Statement of Common Ground with Historic Eng- land (draft)

August 2025

- 1.1.1 This Statement of Common Ground (hereafter referred to as the 'SoCG') has been prepared to support the Examination of the Development Consent Order (DCO) application (the 'DCO Application') for Peartree Hill Solar Farm (the 'Proposed Development').

Figure 7.1: Designated Sites and Ecological Mitigation and Enhancement

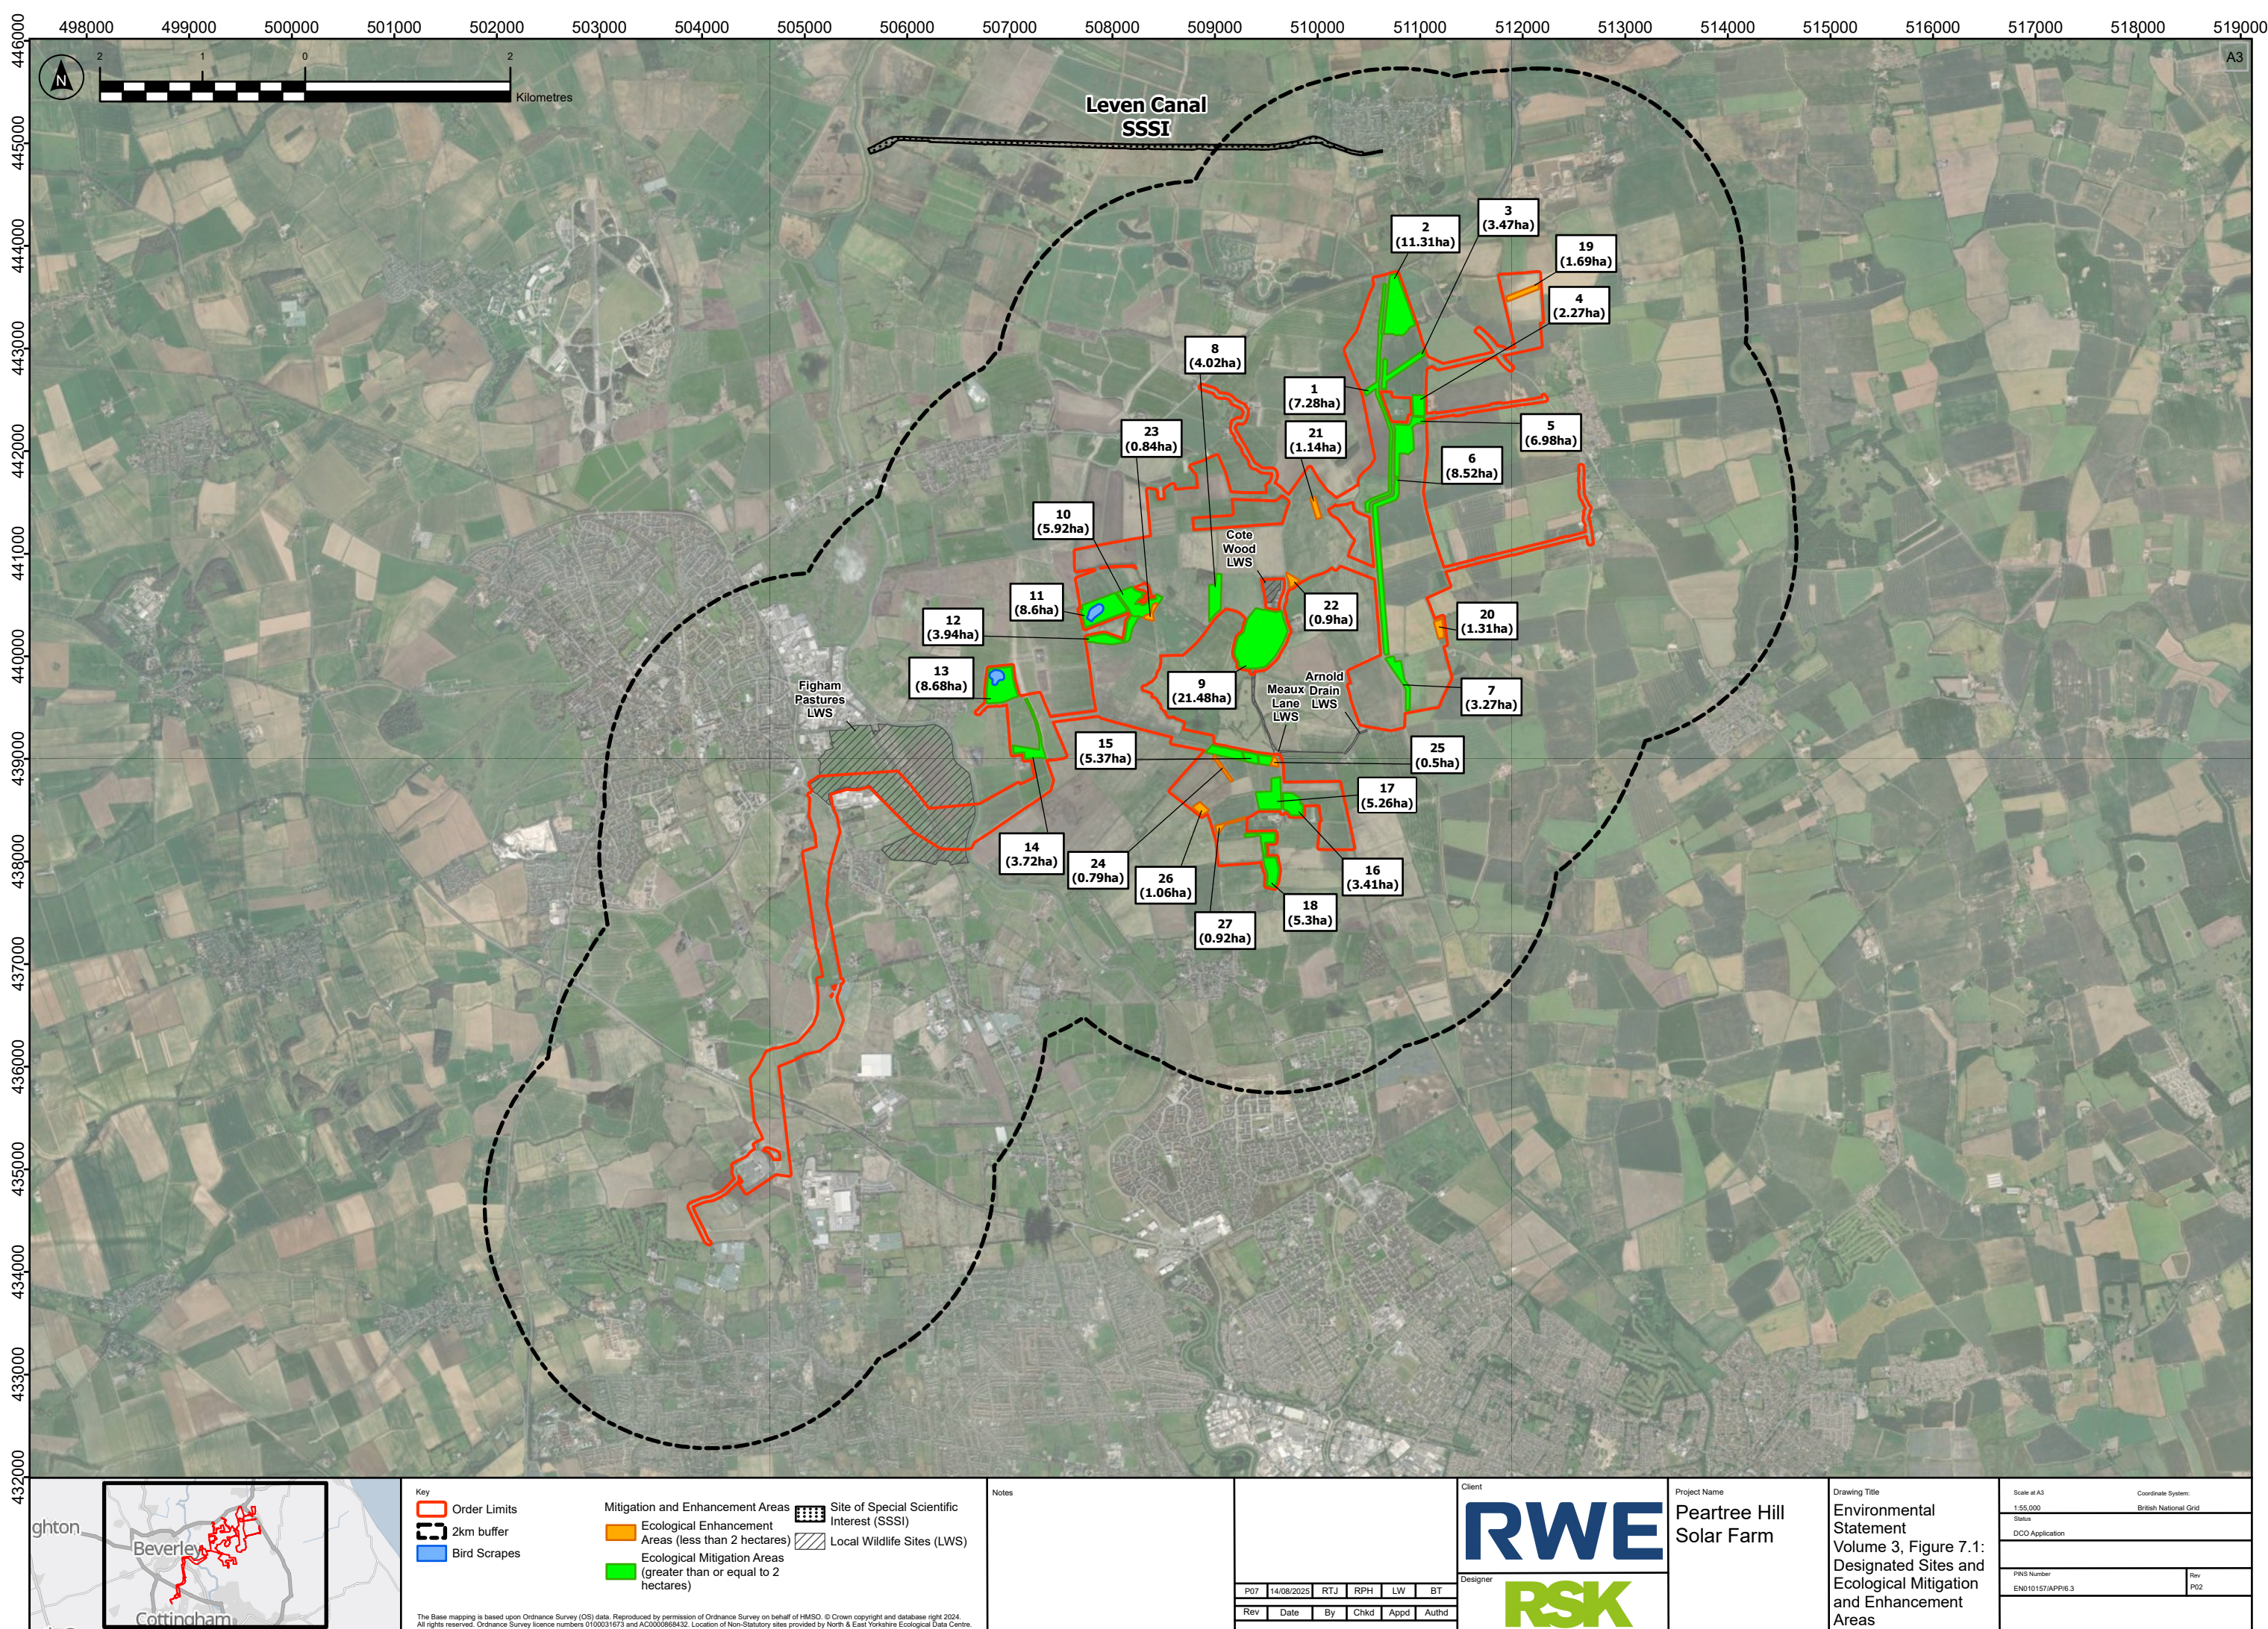
Date	Purpose of engagement	Description
June 2025	To discuss appropriate mitigation in relation to the Applicant's proposal to create bird scrapes in Field E6	Email correspondence to discuss appropriate mitigation of any potential impacts to archaeological remains that may arise through the Applicant's proposal to create bird scrapes in Field E6 to the north of Meaux Duck Decoy.

Ref	Topic	Historic England Position	Applicant's Position	Status
HE07	<p>Archaeology – trial trenching of bird scrape areas</p> <p><i>Cultural Heritage</i></p>	<p>Historic England confirmed via email on June 5 2025 that archaeological trial trenching would be required within Field E6 prior to the creation of bird scrapes in this field, and that this could be carried out as a post-consent requirement of the DCO. The detailed scope would be set out in a Written Scheme of Investigation, substantially in line with the Archaeological Management Strategy.</p>	<p>The Applicant agrees to this request. The Archaeological Management Strategy [EN010157/APP/7.11 Revision 2] has been updated accordingly and is submitted alongside this document at Deadline 1.</p>	Agreed
